From: Nicola Spencer on behalf of Planning.Responses
Sent: 26 January 2018 14:10
To: Julia Mills
Subject: FW: AL/114/17/NMA 27A Belle Meade Close
Attachments: Prop Elevations 1 Model (1).pdf

This NMA proposal merely seeks to reduce the eaves height of the new detached garage roof, whilst the ridge remains the same height as approved – surely this is just such a minor amendment to the approved plan that can be accepted as a Non Material Amendment?

Subject: AL/114/17/NMA 27A Belle Meade Close

PROPOSED ELEVATIONS

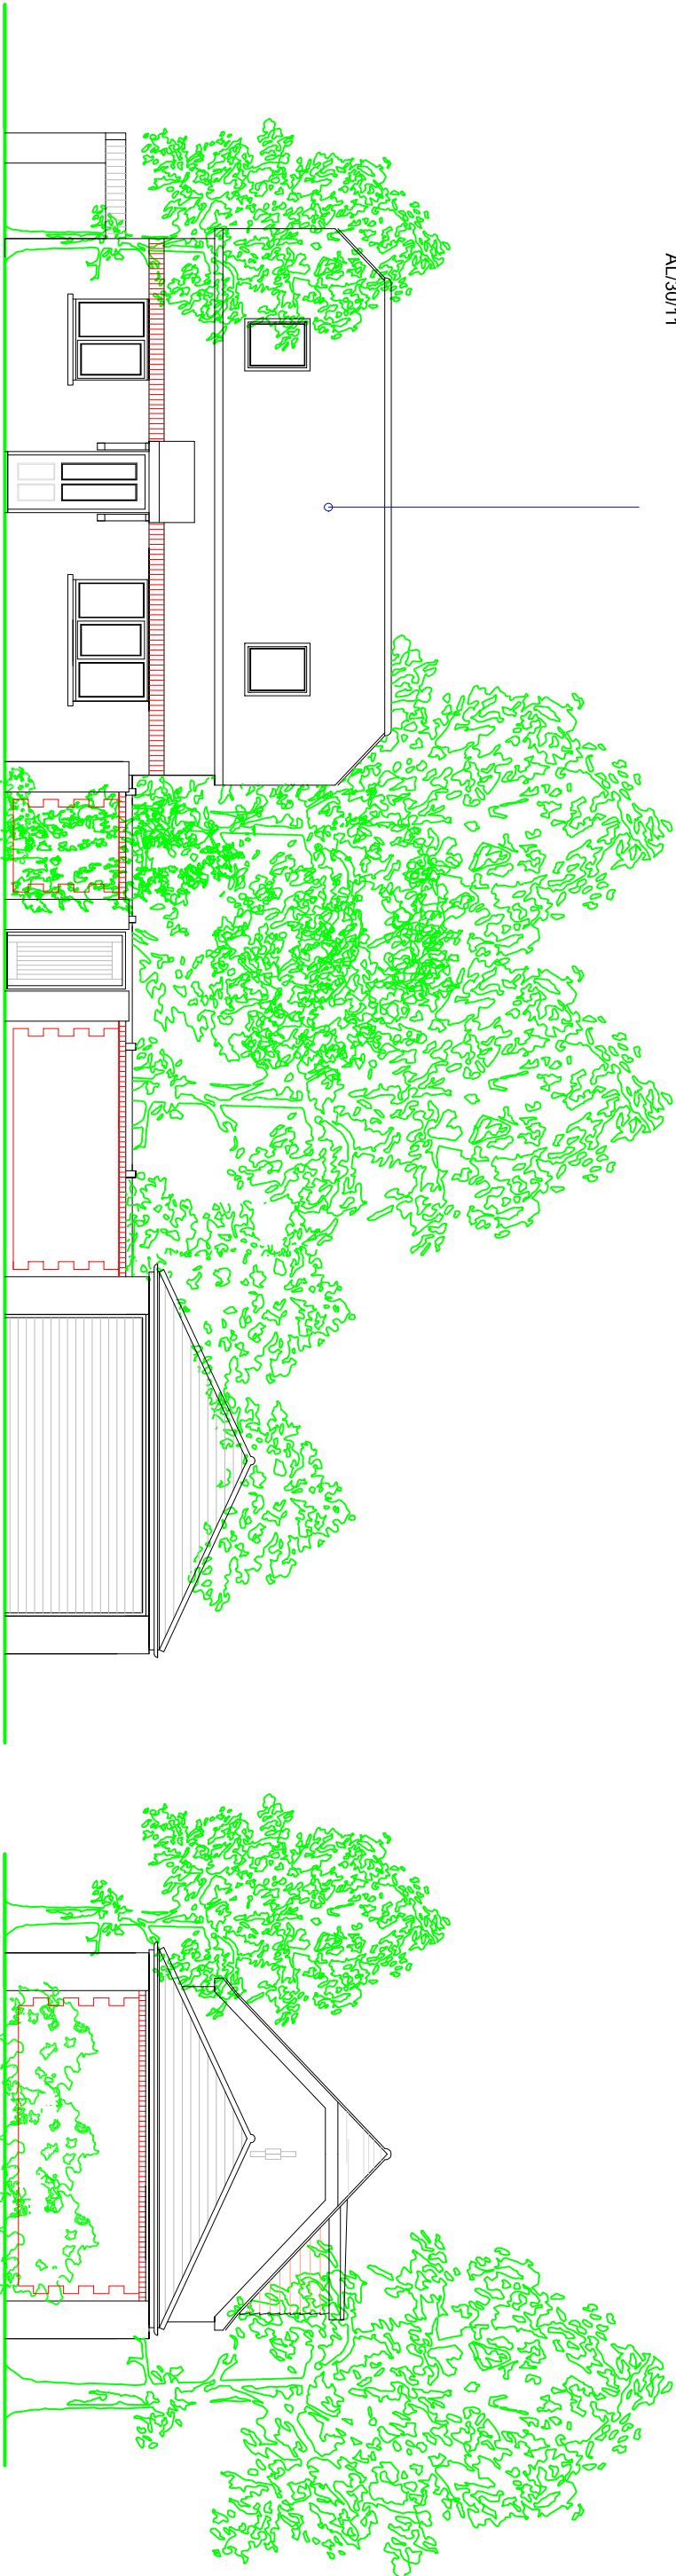
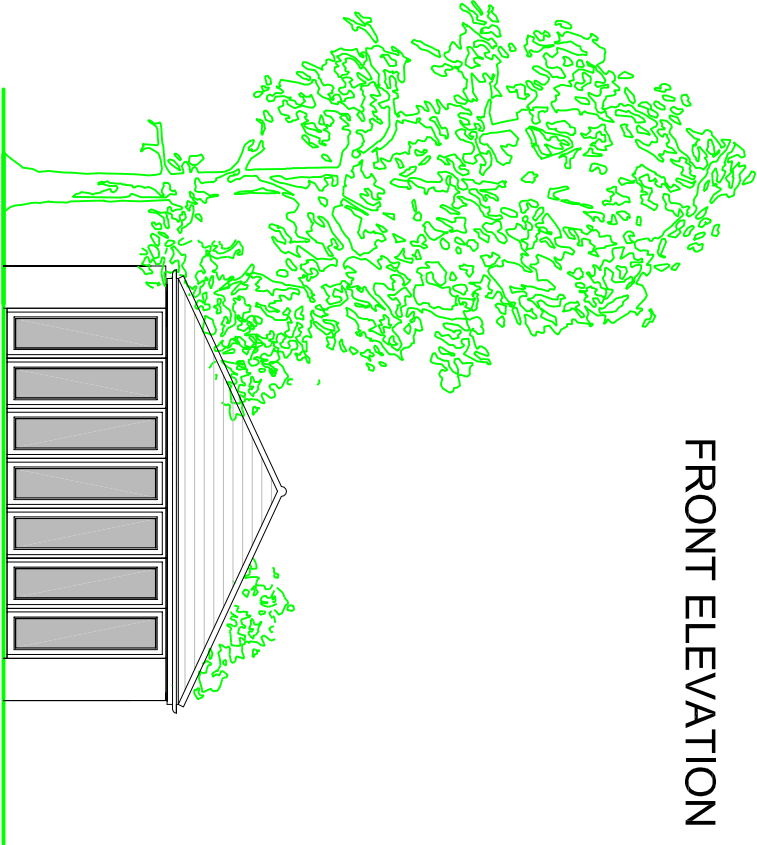
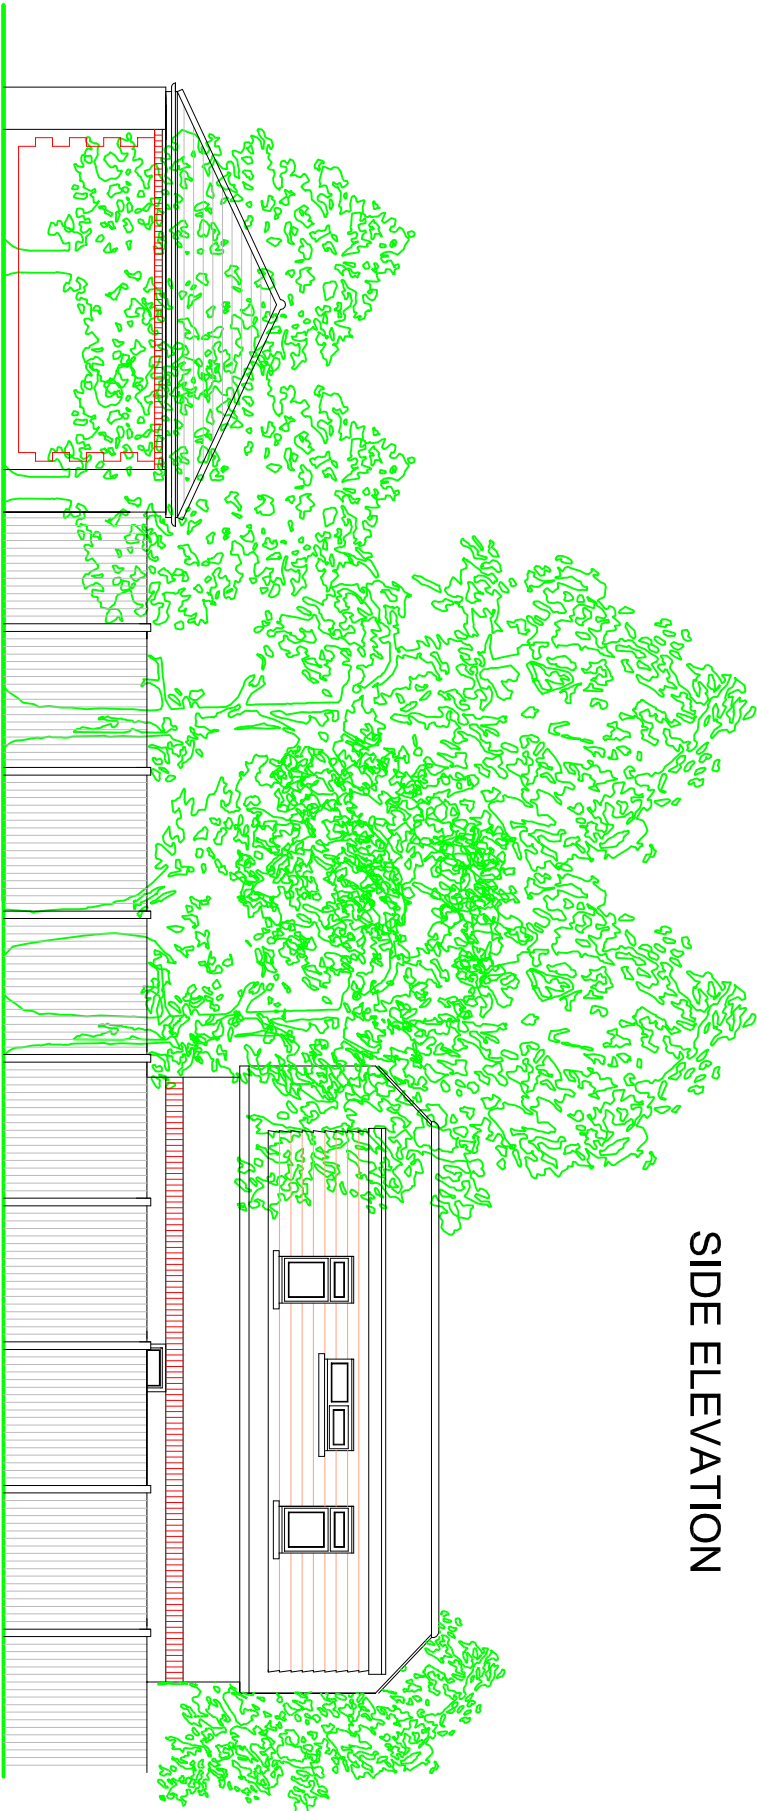
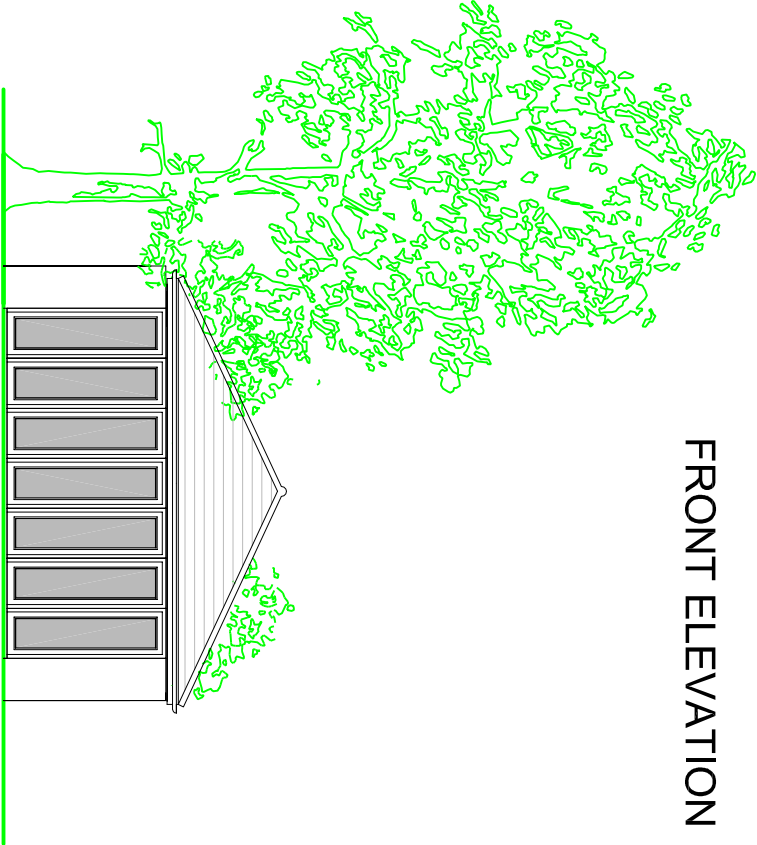
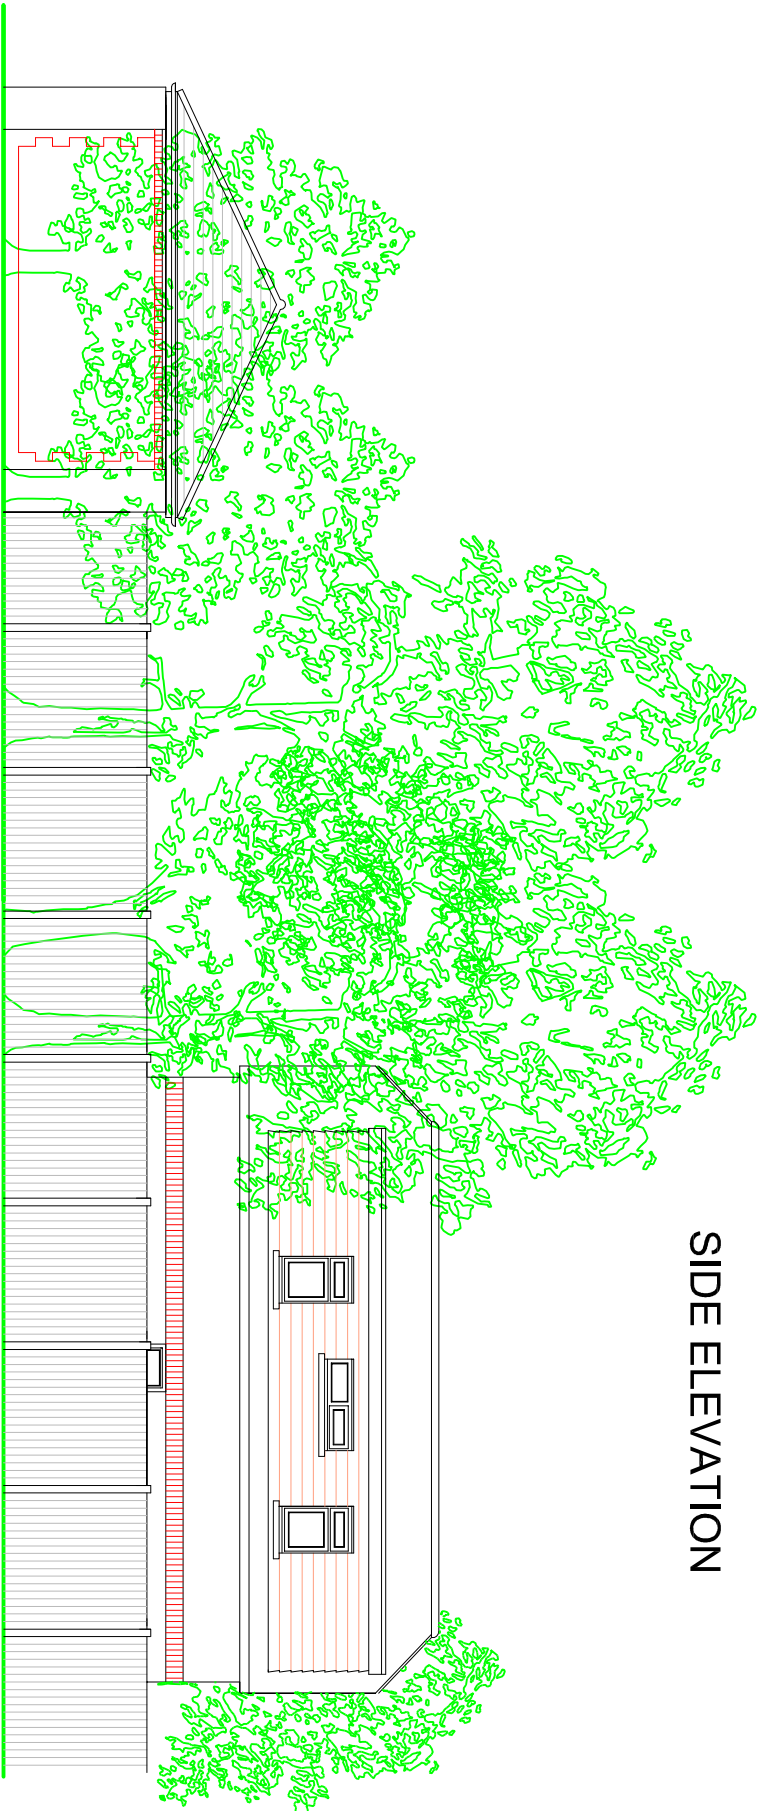
* You say that the height of the boundary walls will increase. However, the submitted plans do not make it clear which boundaries are being increased and to what. The approved plans show a mix of 1.9m and 2.1m fences/walls. The submitted plans seem to concur with the measurements on the approved plans. Can you explain where this change relates to and what the increase is.

* It is unclear what the infill wall relates to. Is this to either side of the new folding doors to the garage?

However, notwithstanding the above I have reservations about whether this can be considered as a NMA. I attach our latest internal NMA guidance. The proposal effectively creates a garage where there was not one previously (the approved plans are unclear as to whether there was to be a structure in this location or not). This would seem to materially alter the approved scheme. Furthermore even if there was a structure, then the increase in height of this is in excess of 0.3m.

The attached Proposed Elevations 1 which is what has been approved on AL/25/12/, and Proposed Elevations 4 is what is being sought.

PROPOSED ELEVATIONS

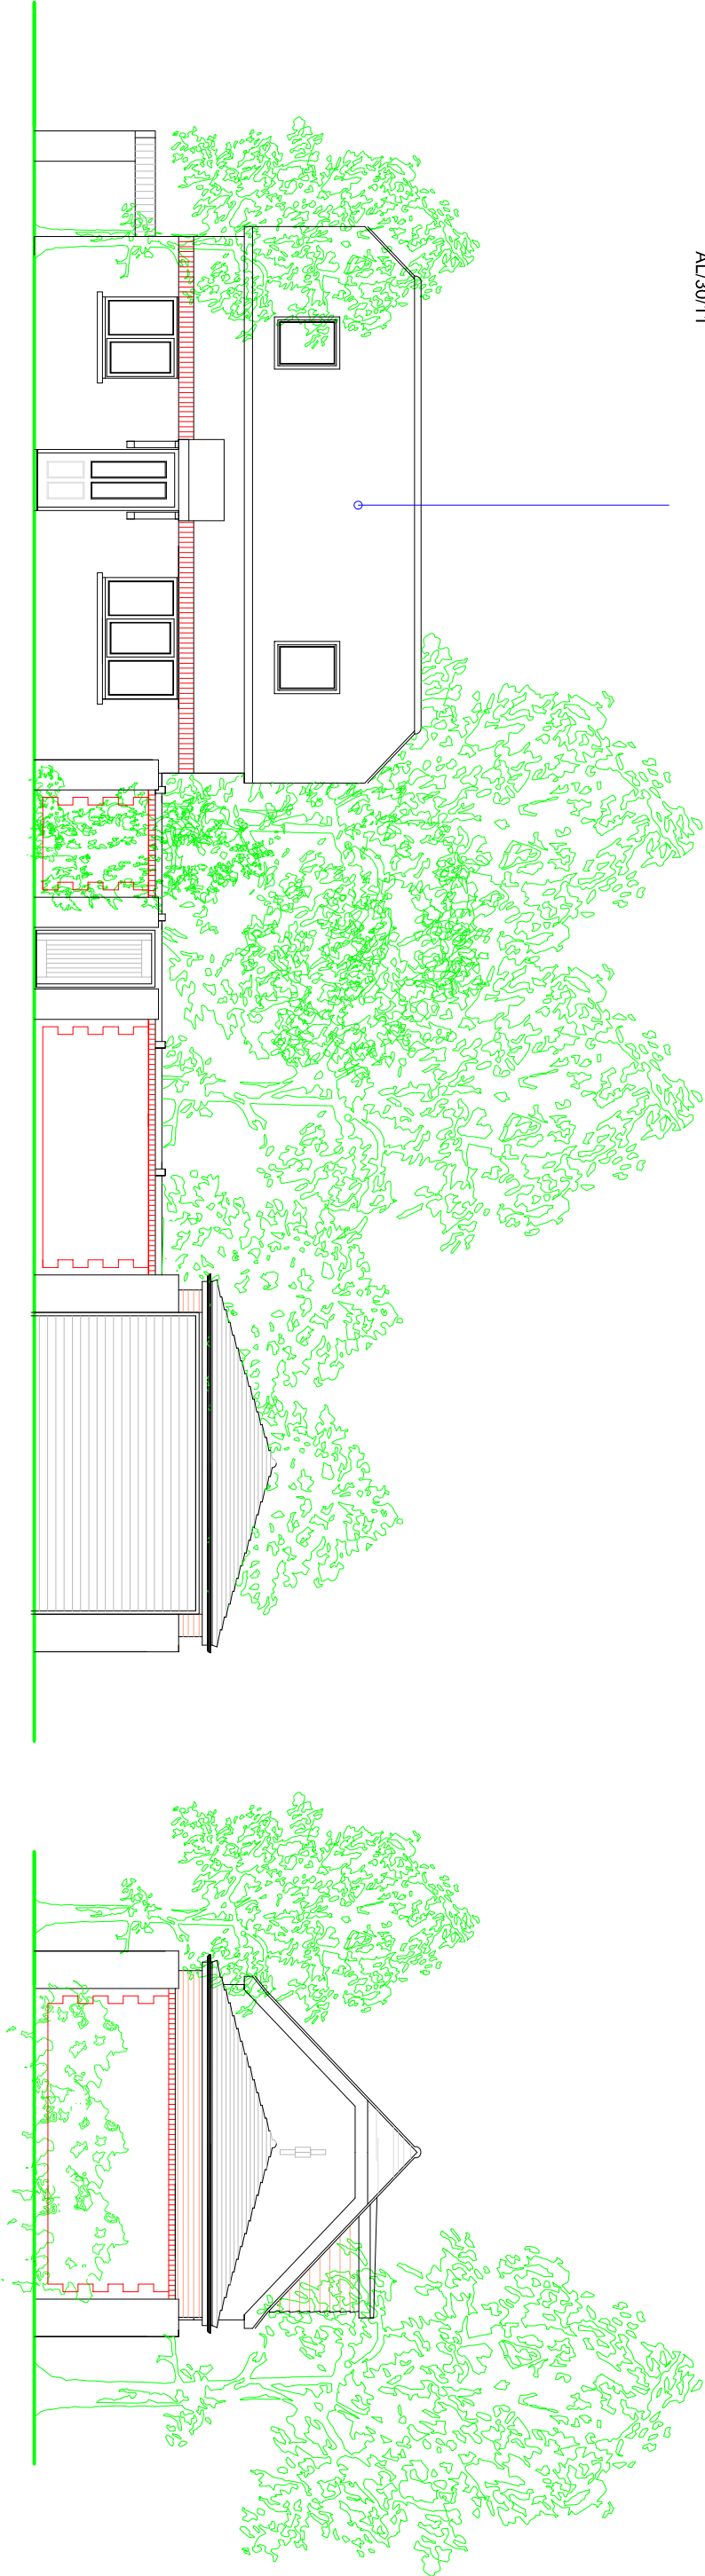
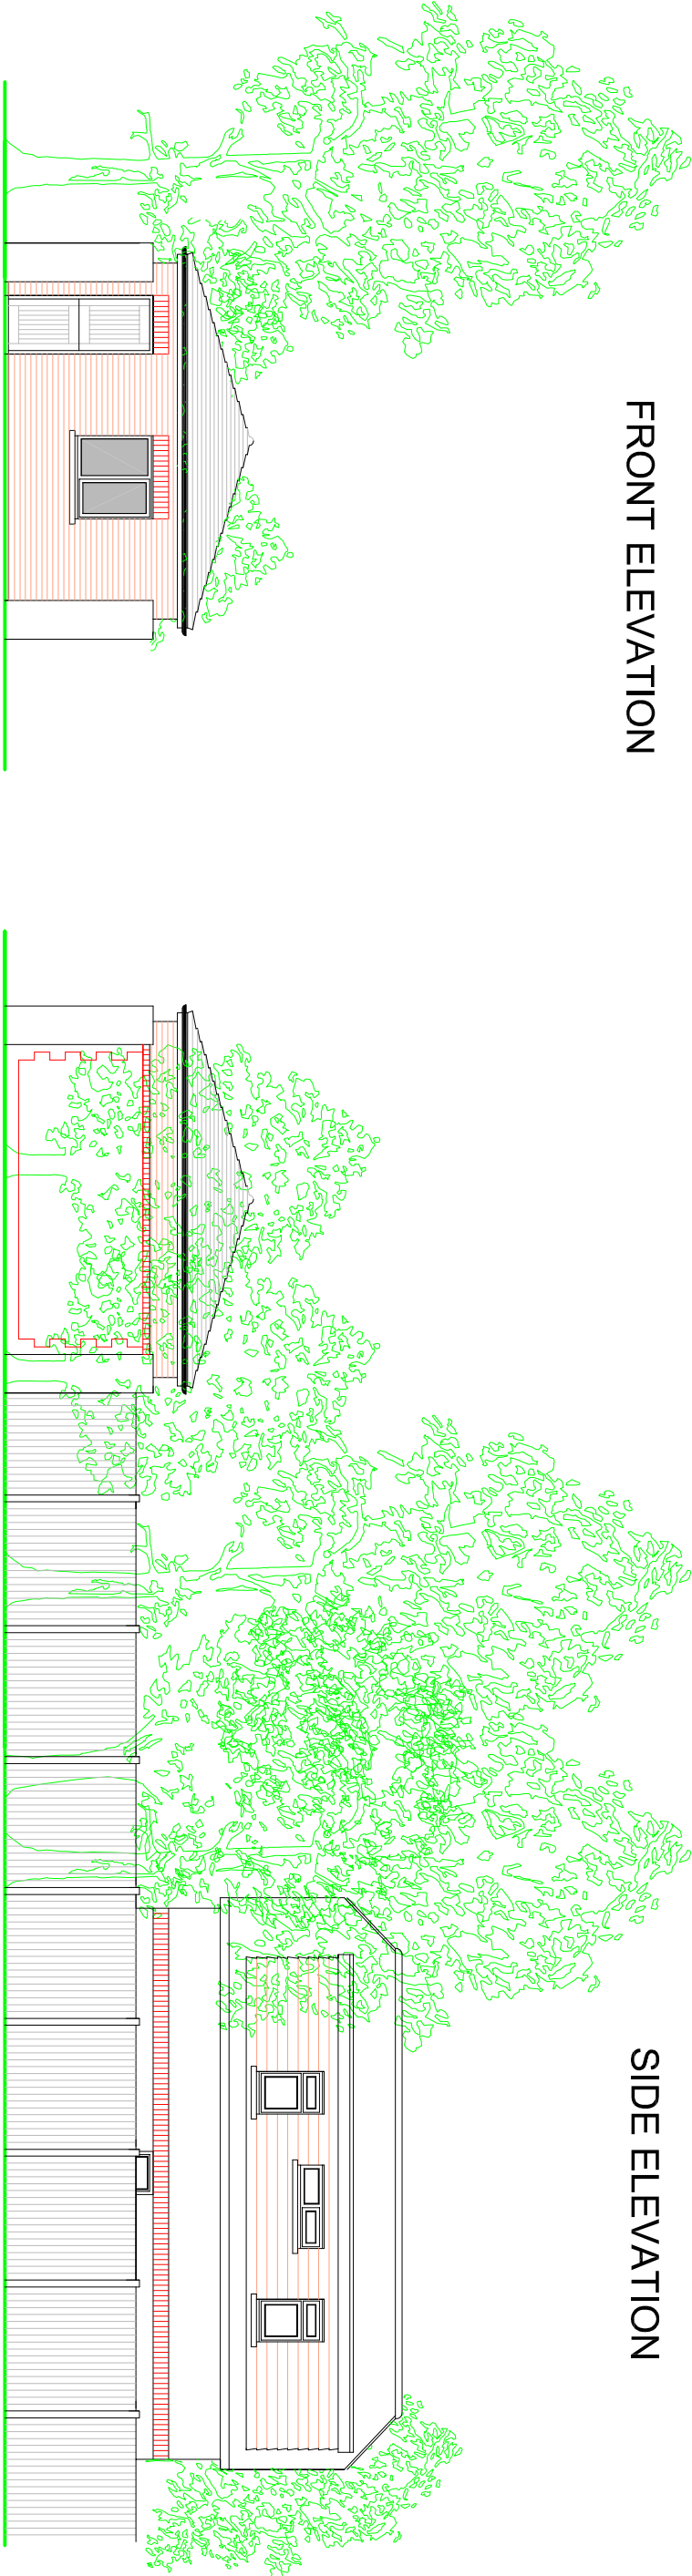
Although the attached states Proposed it is actually a plan of the existing and I would like uploaded for reference purposes so it is clear what is being changed.

The planning application AL/25/12/ was approved showing the existing boundary walls to be raised to form the new detached garage walls and a low slung pitched roof placed on top.
